## On-Demand Storm-Water - Open Responsive Action Log

Customer: **South**  
Division: **ALB - Albuquerque**  
Project: **Stormcloud 5**

### Stabilized Construction Entrance

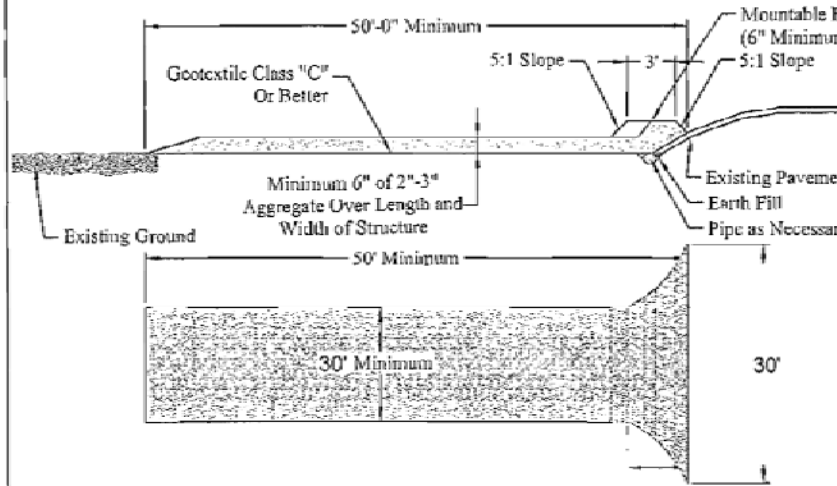
| ReportID | Report Date | Ref#      | Responsive Action Needed | Location               | Date Corrected | Corrected By | Explanation |
|----------|-------------|-----------|--------------------------|------------------------|----------------|--------------|-------------|
| 392491   | 5/7/2020    | 392491-B1 | Re fresh VTC             | 8508 camino del venado |                |              |             |
